Application for a Non-Material Amendment Following a Grant of Planning Permission

New single storey front extension and new detached timber clad car port.

EP/104/24/HH

Increased width to the proposed detached car port

P012 P2 PLANNING

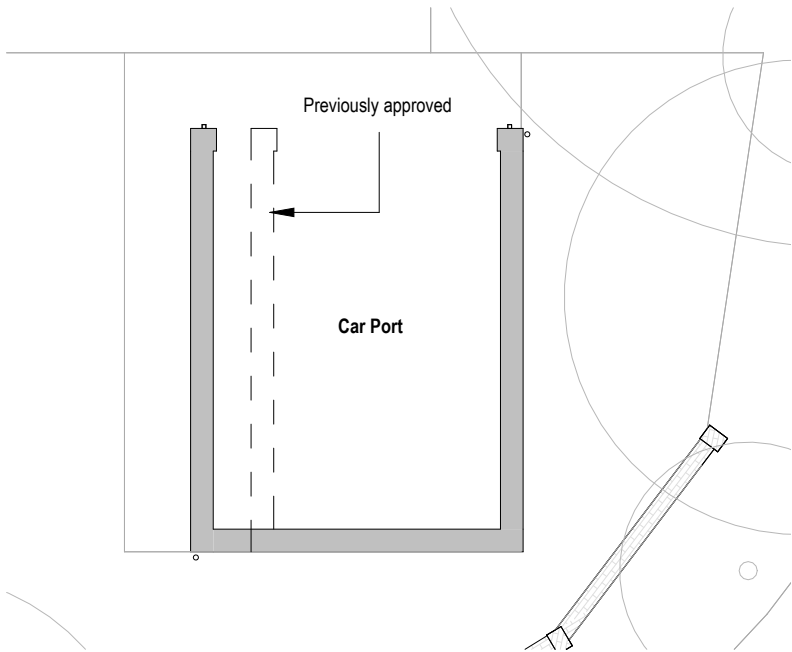
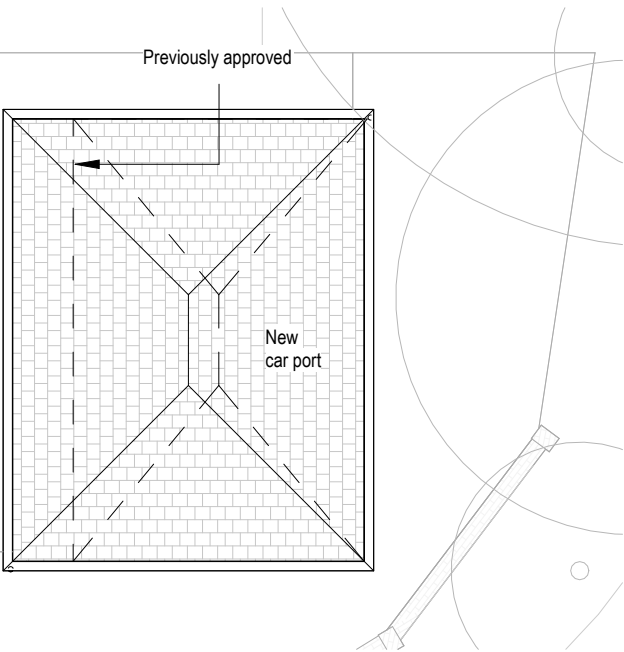
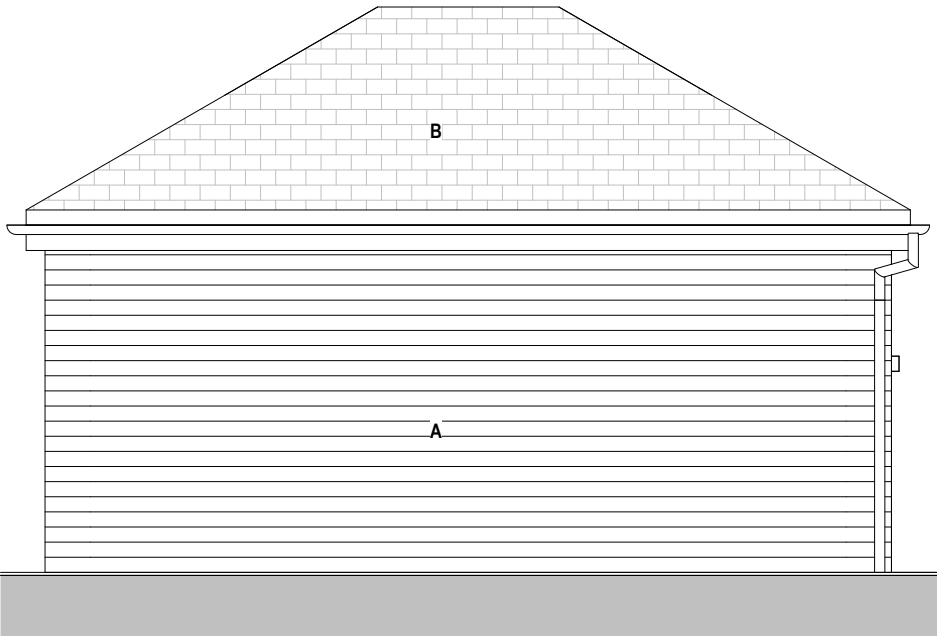
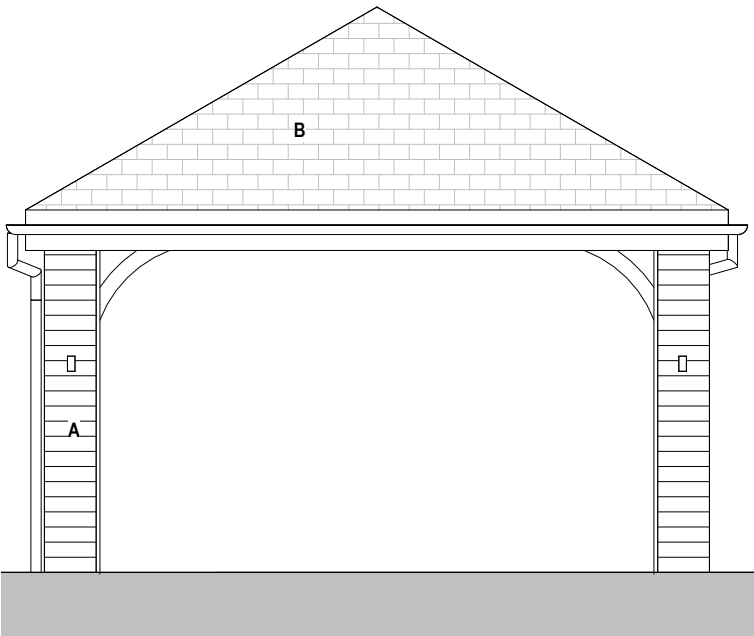
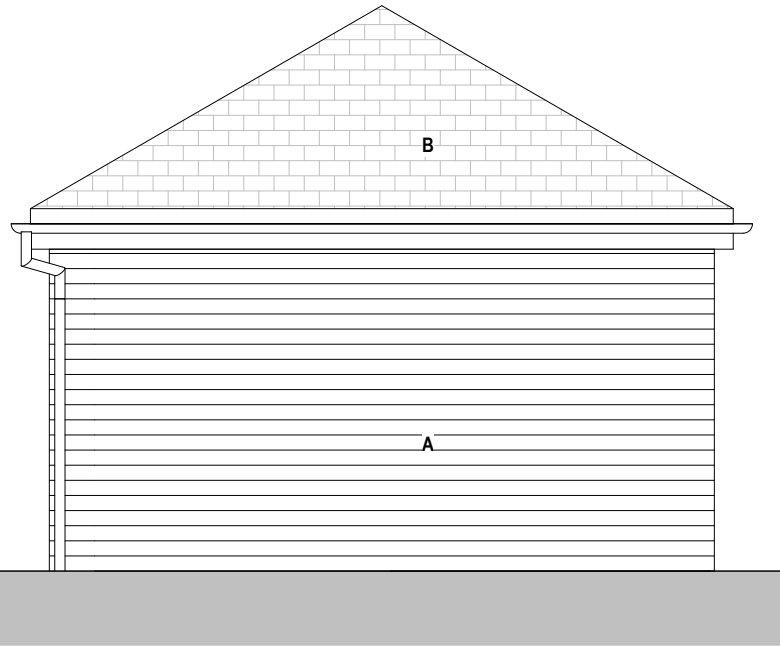
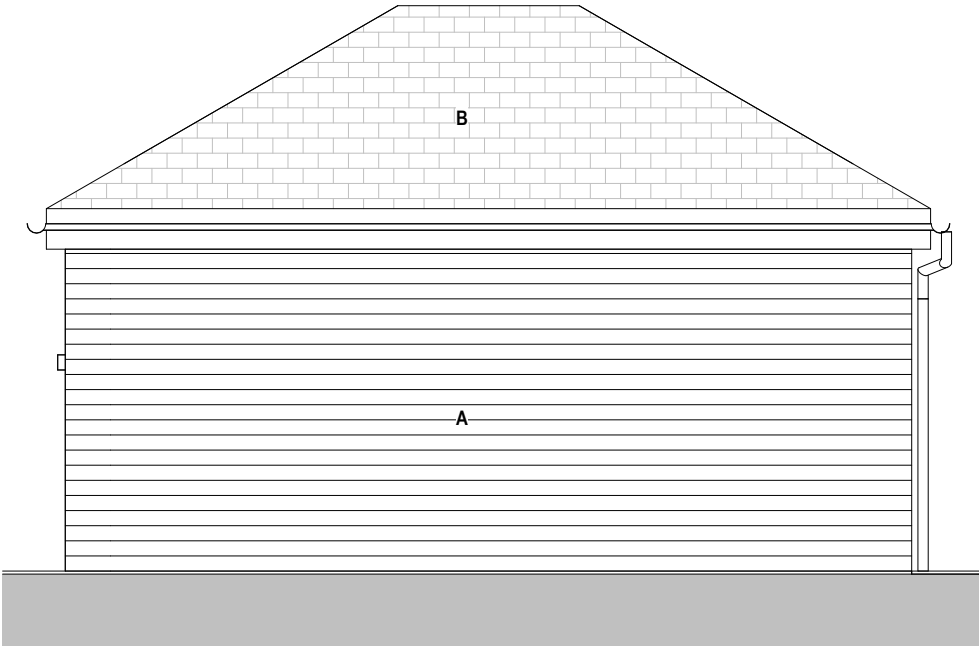
To suit a preferred product

P012 Rev2
